DEVELOPMENT REVIEW BOARD MEMO

DRB CASE NO/PROJECT NO: 1007270

**May 14, 2008
DRB Comments**

**RE: Lots 17, 18 & 27, Los Hermanos Subdivision; MRGCD Tract
22-B, Map #33; Lot 1-A, Manual Sanchez Subdivision**

**PLAT OF
 LOT 1-A-1
 MANUEL SANCHEZ SUBDIVISION
 AND
 LOT 27-A
 LOS HERMANOS ADDITION**

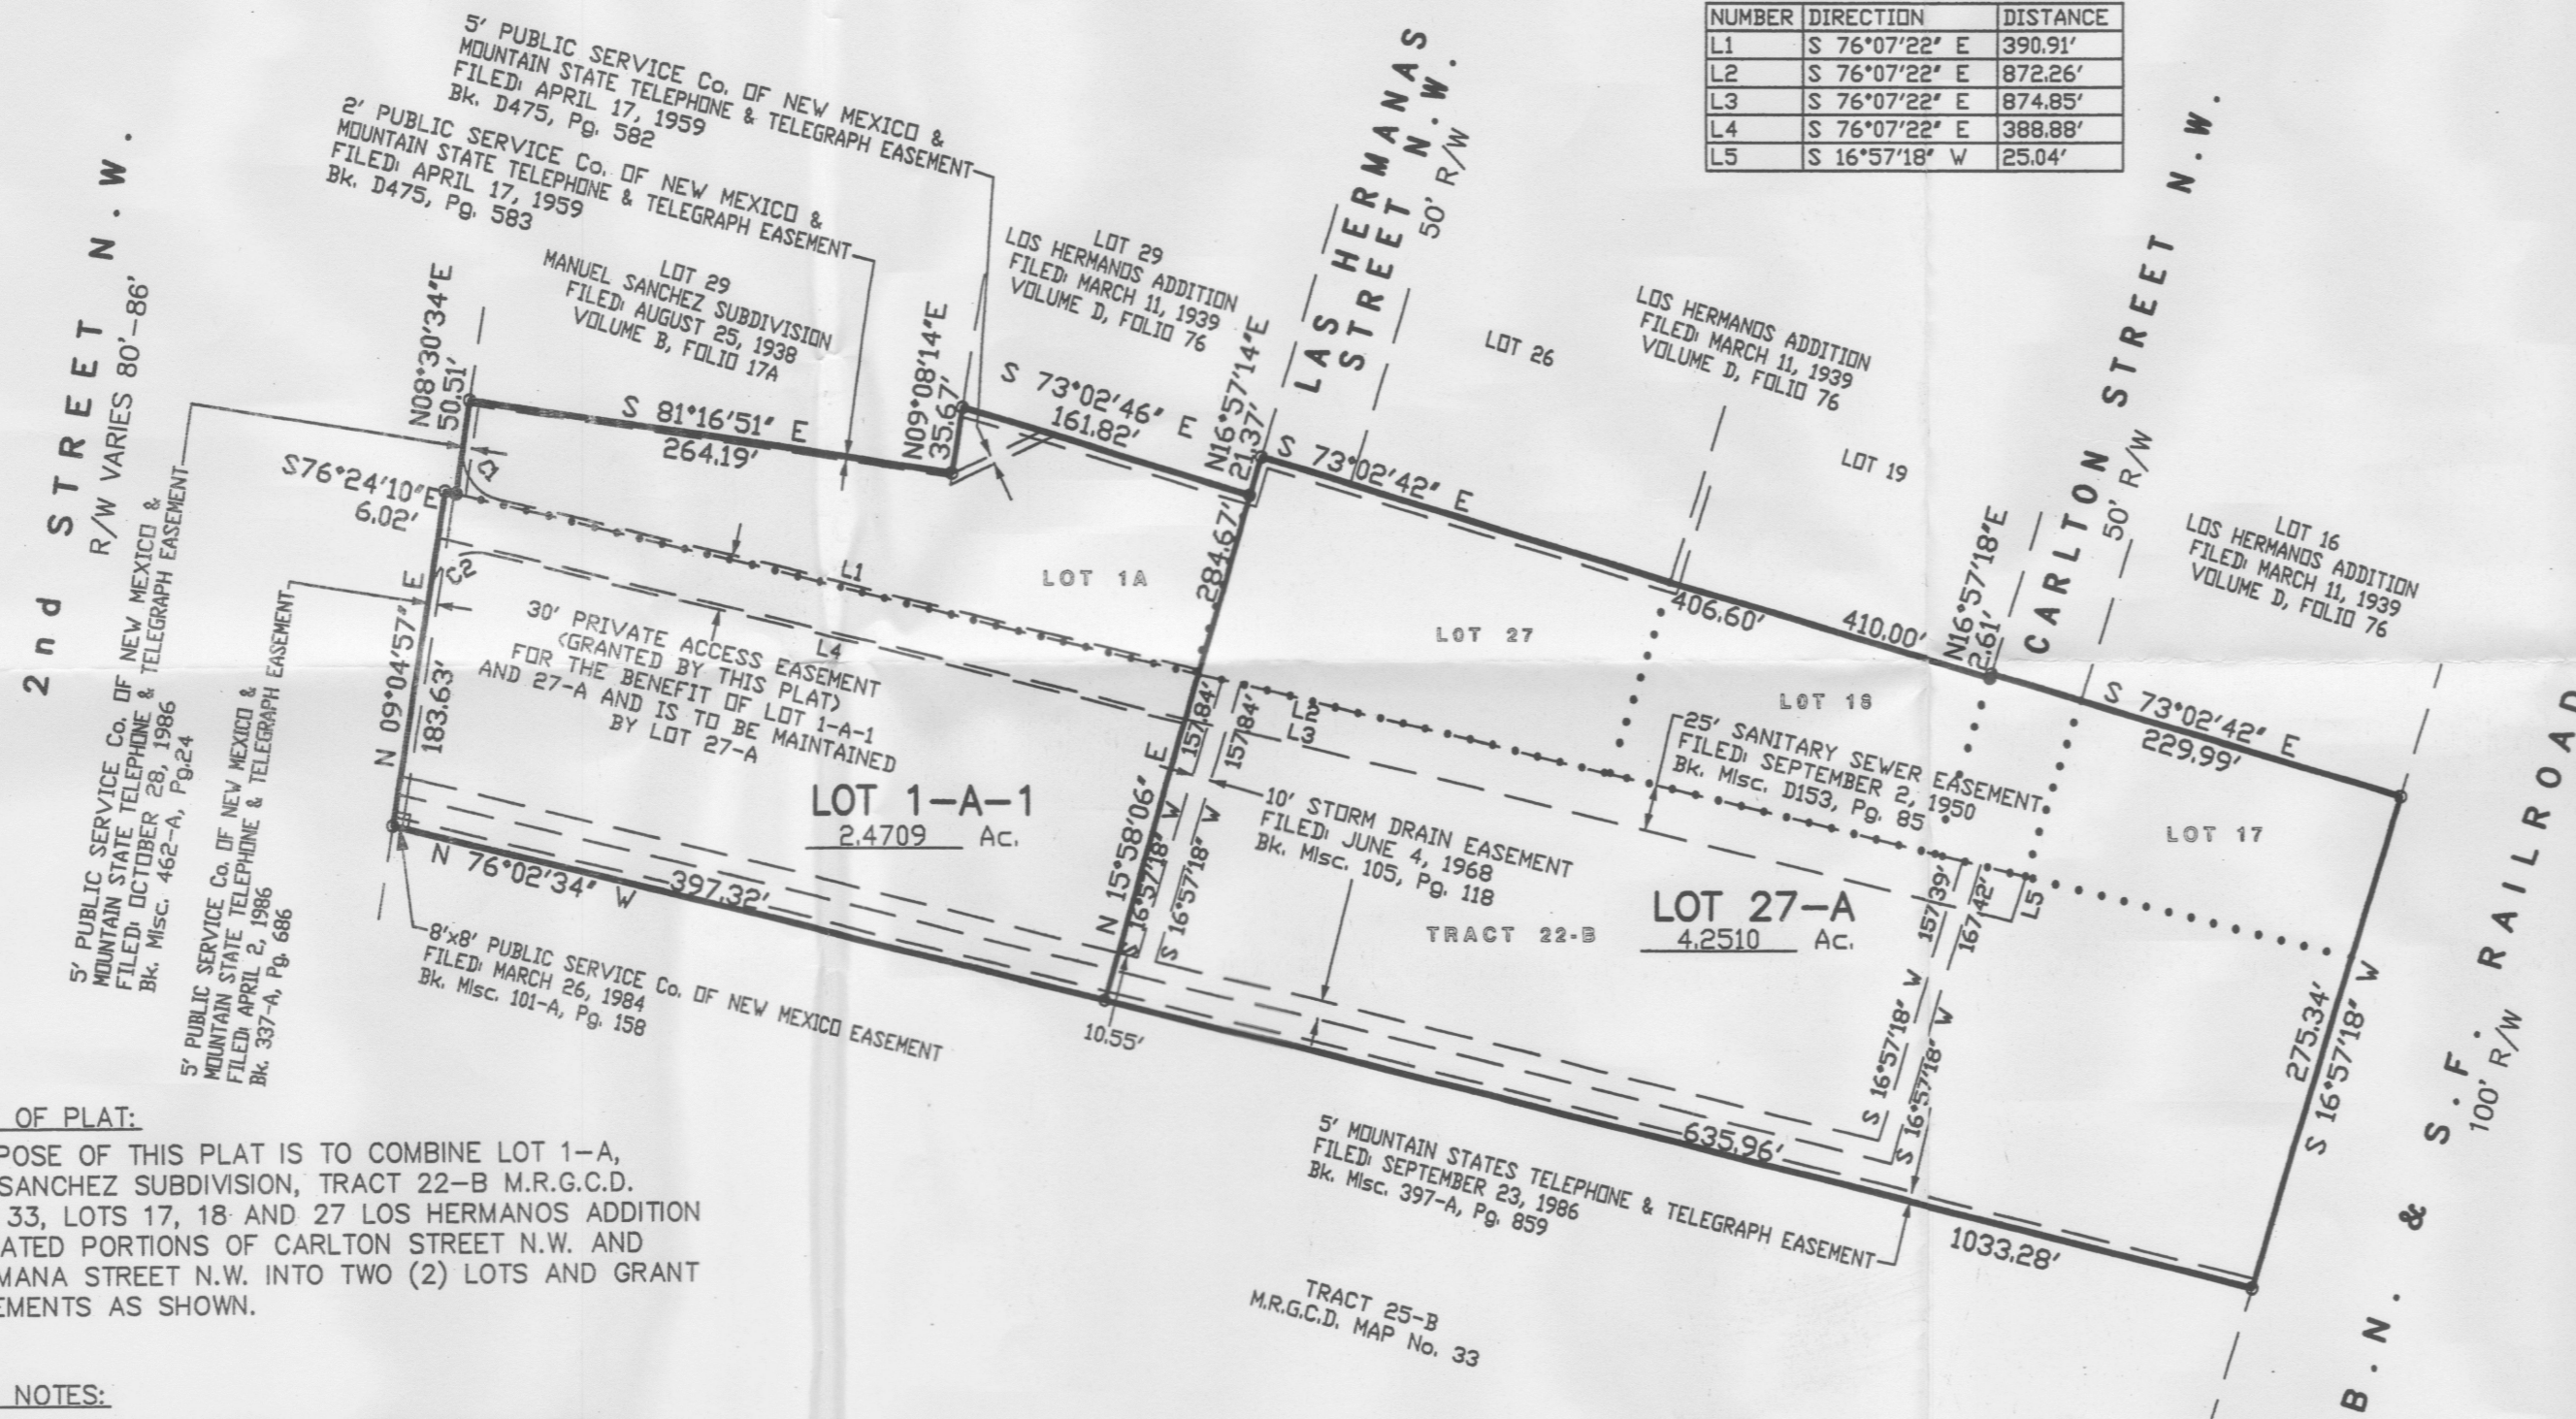
Requires a Drainage Report.

Please reference vacation actions on plat – it appears that
turnarounds may be needed at the terminus of Las Hermanas Street
and Carlton Street.

1. There are 2 existing water/sewer accounts for the property. Need to know the status of water/sewer services to the 3 buildings on Lot 27-A.
2. Plat needs to show a public sanitary sewer easement in the vacated Carlton St.
